URBAN DESIGN BRIEF
THE PROPERTIES GROUP
O'KEEFE COURT

December 2024

The applicant was requested to provide an Urban Design Brief to address the comments provided by Christopher Moise in an April 17th, 2024, memorandum.

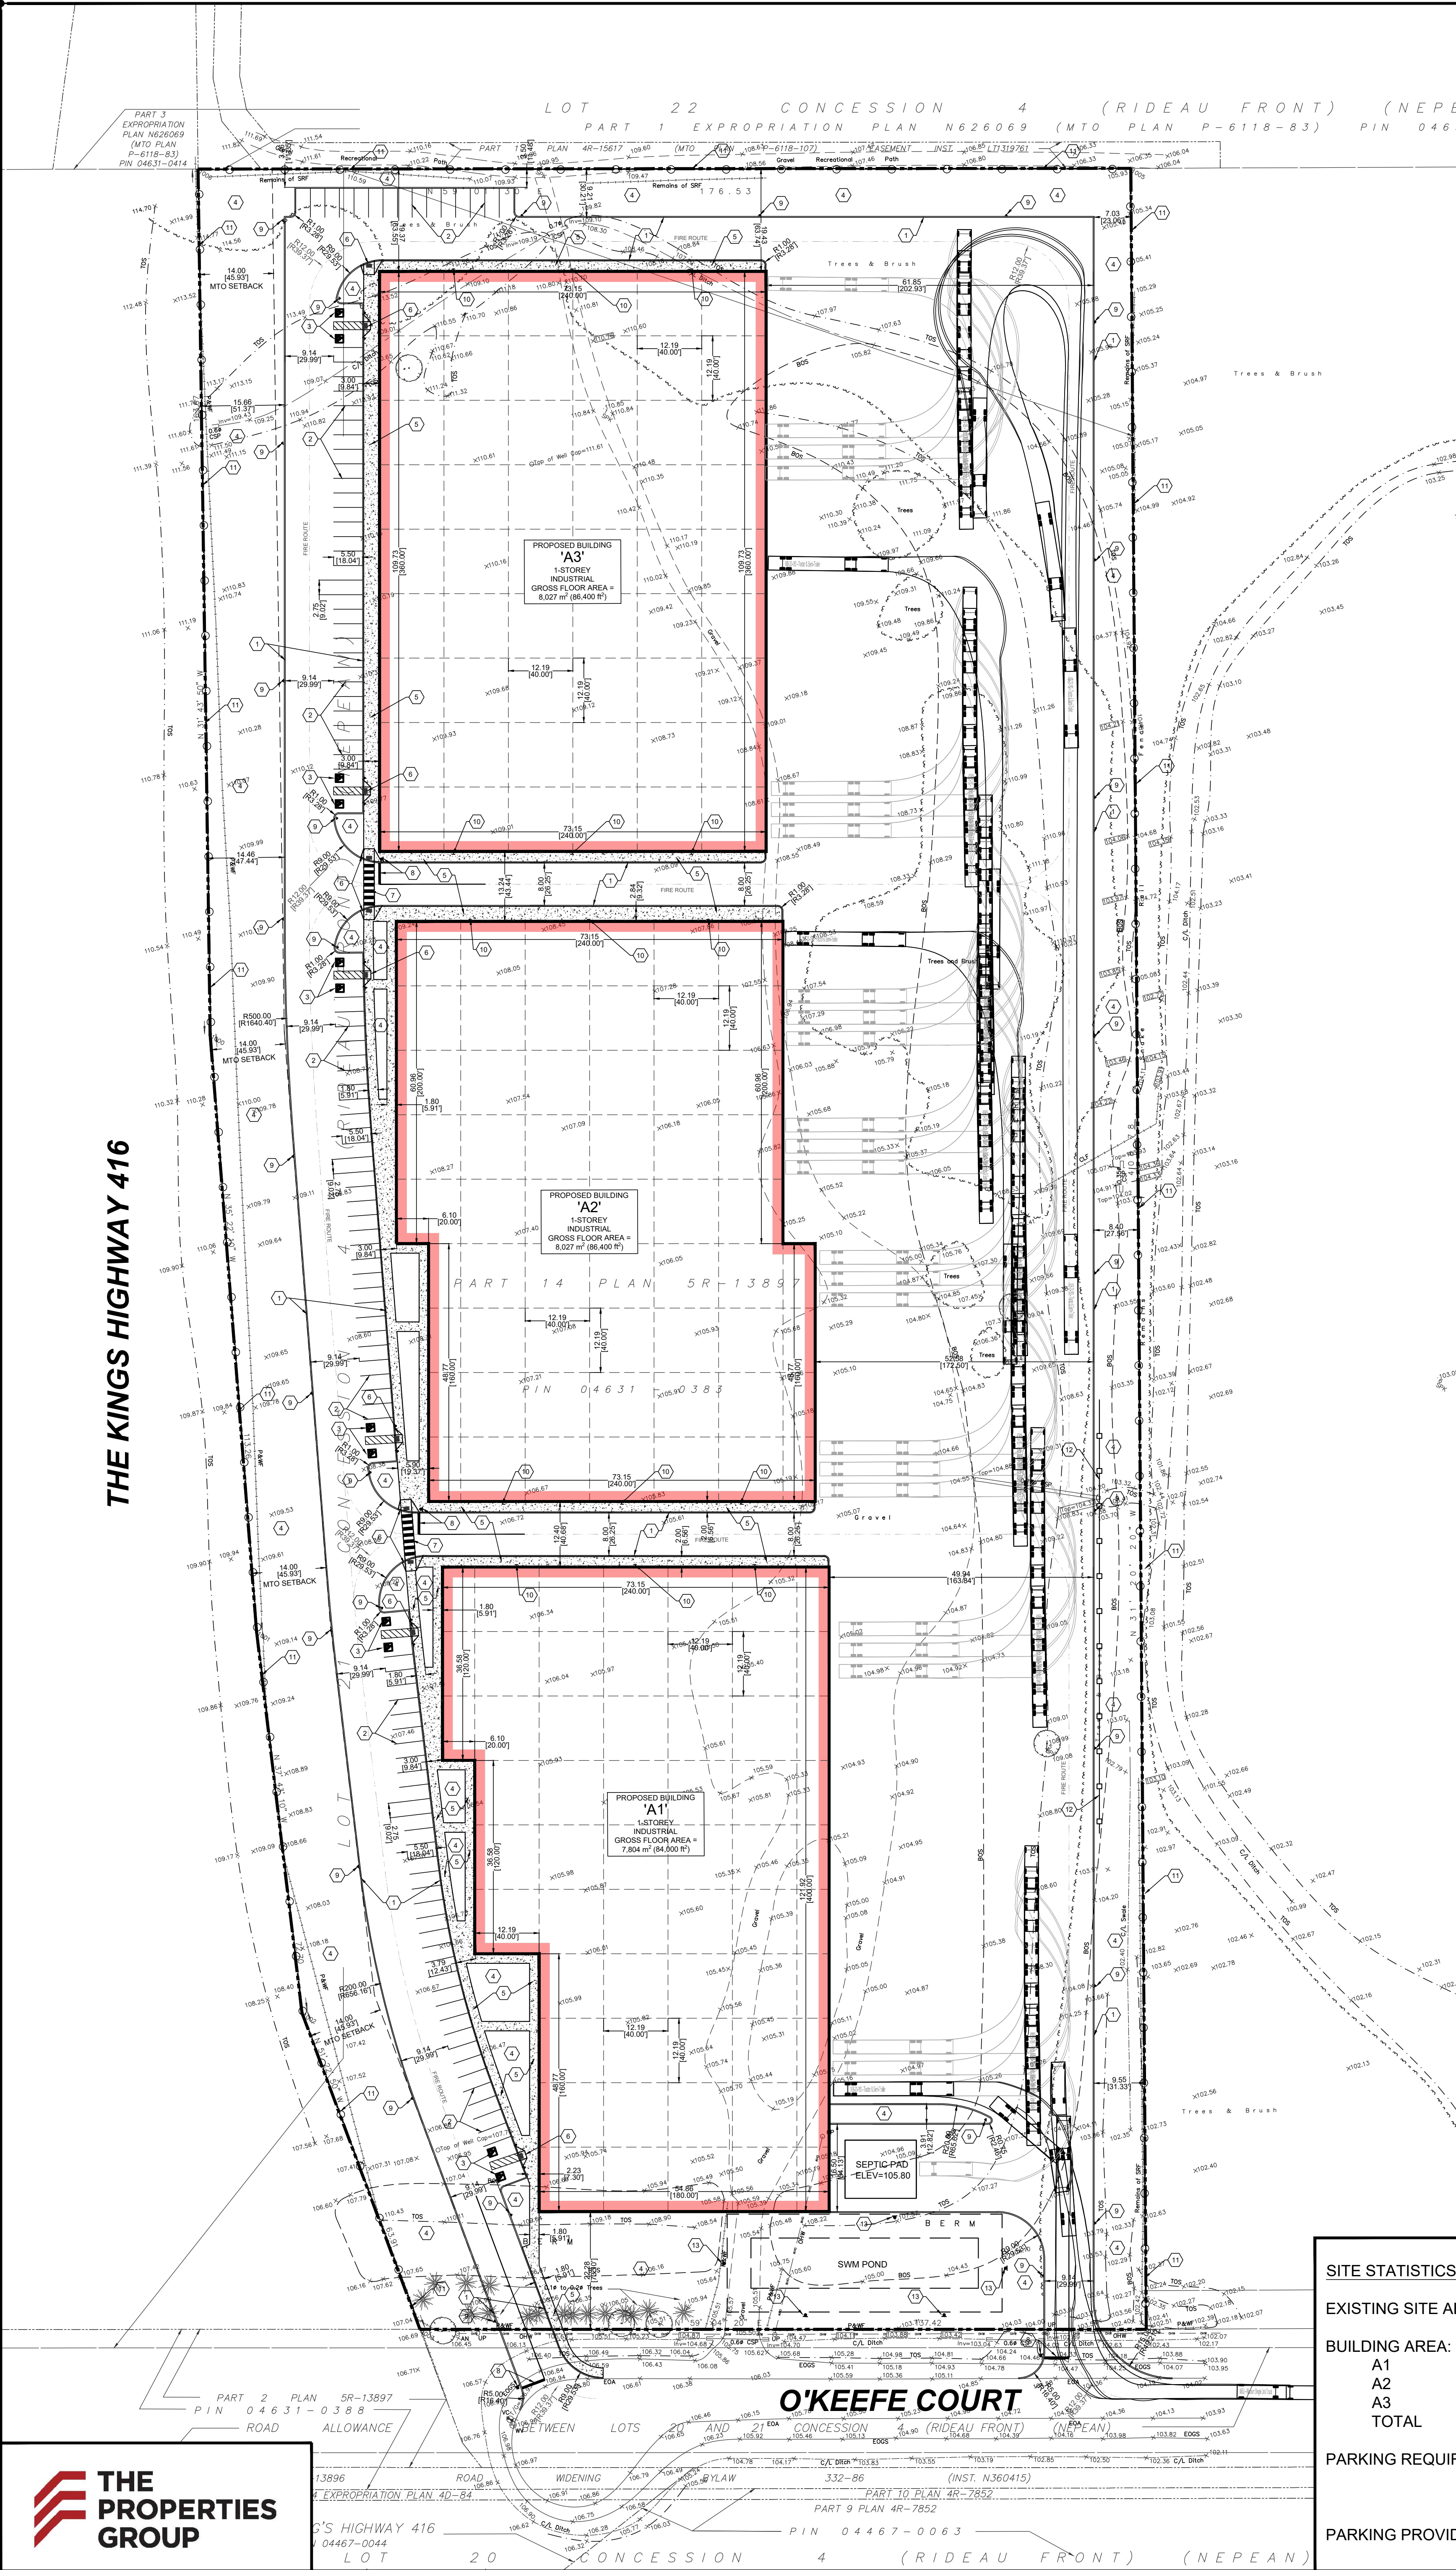
3. The development will be prominent when viewed from the on ramp and highway. The entire length of the west property edge needs to be well landscaped.
4. The distance between the east property edge and the edge of pavement is shown at between 9.55m – 7.03m. The entire length of this edge should be heavily landscaped to screen the use from the park.
5. The frontage along O'Keefe will also need substantial landscaping, if the parking area remains out front.

6. The submission drawings need to show the locations of doors, as well as the width and location of pedestrian walkways from the parking areas to the doors. They should also show a connection out to O'Keefe.
7. If there is more parking than required by the zoning by-law, then the total number of parking spots should be reduced. For example, can the parking facing O'Keefe be removed? Can some of the parking facing the highway be deleted?

The City's 'gateway' design objectives for this area places importance on the visual appearance from O'Keefe Court as well as Highway 416. The site design incorporates a 14 metre setback along Highway 416 appropriately landscaped to meet MTO requirements and highlight the upgraded exterior building elevations fronting Highway 416. In addition, the landscape plan responds to that desire by providing a heavily landscaped frontage which retains existing trees along the O'Keefe Court frontage and enhances them with new large format trees comprising Red and Freeman maples and new Basswood trees.

To address the City's 'gateway' design objectives, no perimeter parking facing Hwy 416 is proposed. Required parking is situated more in-bound to the site, and nose-in against the buildings. This mitigates perceived visual effects of cars facing Highway 416, and permits proposed landscaping and upgraded building elevations to create desired stage presence for the site from Highway 416.

On the eastern property line the proposed development abuts Lytle Park an 11 hectare park with sports field and the Carl Faulkner Ball Diamond. The area abutting the property line is extensively landscaped on the park side and a chain link fence is proposed separate the land uses. However, a small section of the park side vegetative buffer is thin. To compensate it is proposed augment the buffer with a row of Maples and Basswood trees as illustrated below.

Landscaping is something that can enhance along the right of way. The proposed landscape plan proposes extensive plantings along the 416 right of way and along O'Keefe Court. Along the 416 the Ontario Ministry of Transportation mandates a 14 metres MTO setback from the property line. In response to the City's urban design comments and the Official Plan Policy a review of the landscaping in the MTO setback was undertaken to determine if that landscaping could be enhanced with additional planting. To ensure that any landscaping would meet with MTO approval contact was made to determine specific MTO planting requirements (see attached email). The MTO response was as follows:

Given the lukewarm response by the MTO the landscape plan kept the planting within the 14 metre setback sensitive to the concerns of the MTO.

The three proposed buildings are situated to face Highway 416 and effectively shield the shipping and receiving activities from Highway 416.
